Examination Library Reference	Chapter and Title,	Summary of Issue, Paragraph/Table Reference	BCKLWN comments
REP1-016/017	5.8.1 - Design Principles, Parameters and Commitments	<p>Tables 3-2, 3-3 and 3-4</p> <p>The applicants have confirmed that floor levels are proposed to be raised 300mm above the modelled flood level, following post-development scenario flood modelling – this suggestion is consistent for the BESS, the Customer Substation and the National Grid Substation.</p>	<p>The Borough Council suggest that flood modelling results and associated raising of floor levels of this key infrastructure has the potential to increase impacts and this should be carefully considered given the landscape implications raised by the LPA.</p>
REP1-029	5.22 SOCG with Defence Infrastructure Organisation	<p>Reference 1-3, 1-4, 1-5</p> <p>The MOD have concerns on impacts on Precision Approach Radar and requested a Glint and Glare Management Plan, which is disputed by the Applicant.</p>	<p>The Borough Council support the views of the DIO/MOD and await in particular confirmation as to whether a Glint and Glare Management Plan is necessary given the concerns raised.</p>

BCKLWN responses to Deadline

Figure 4-1 Available Construction Routing Overview

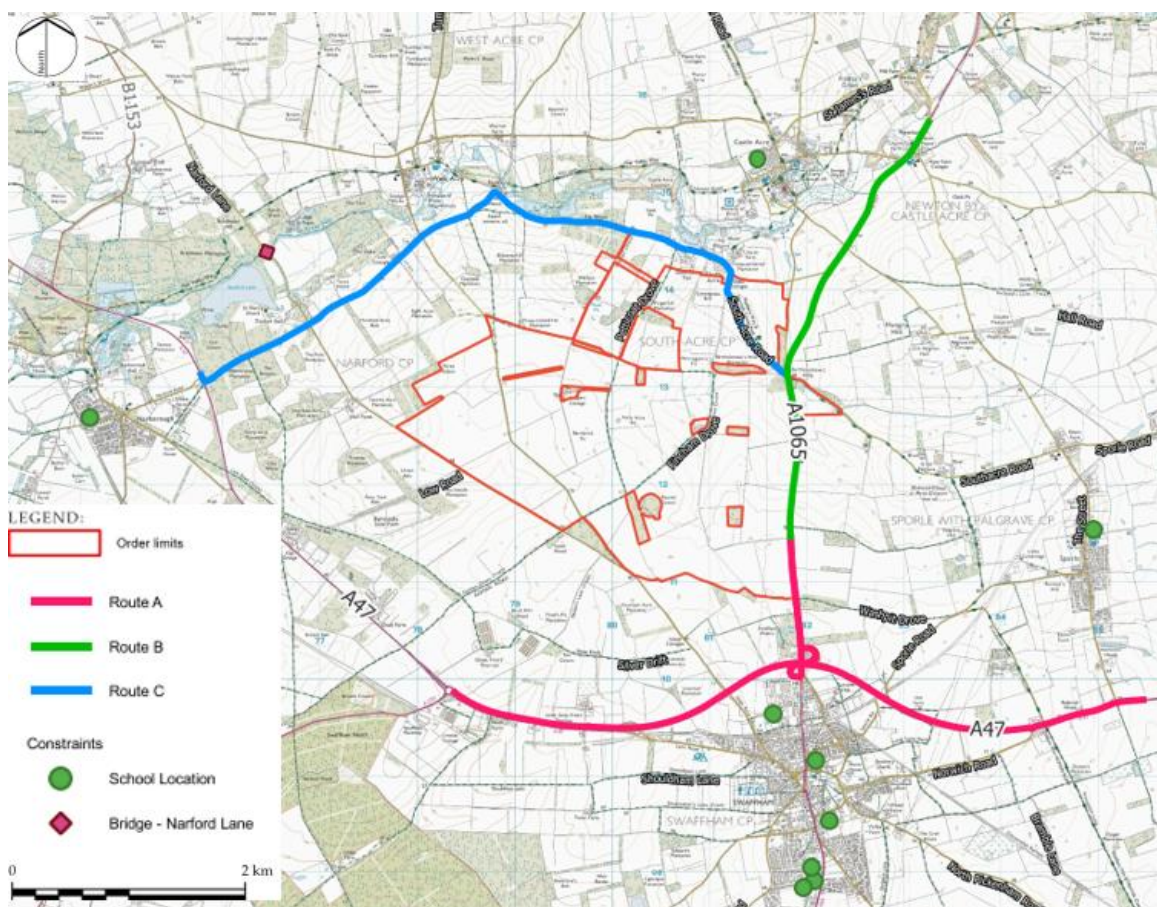
<p>It is encouraging to see that hard measures such as a shuttle bus service to consolidate movements and a restriction on the number of construction parking spaces, these are in addition to the typical soft measures of travel plans.</p> <p>In terms of the shuttle bus, the Applicant refers to conveying staff from construction compounds as well as investigating the feasibility of a shuttle service from staff accommodation and local transport hubs or rail stations (subject to employment strategy). This could mean the shuttle bus extends into outlying settlements including those within this Council’s area. In line with Section 5.2.3 of EN-1 and Defra’s Interim Planning Guidance on PM2.5 that refers to ensuring only the minimum amounts of pollutants being emitted, the Borough Council would recommend that consideration is given to shuttle bus trips being made via electric vehicles.</p>
REP1-052/053	7.7.1 – outline Construction Traffic Management Plan	Paragraph 4.1.3 notes that Route C will not now have any construction vehicles following concerns from NCC over the suitability of this route.	It is noted Part of Route C is within BCKLWN area. The Borough Council have no objection to this change.
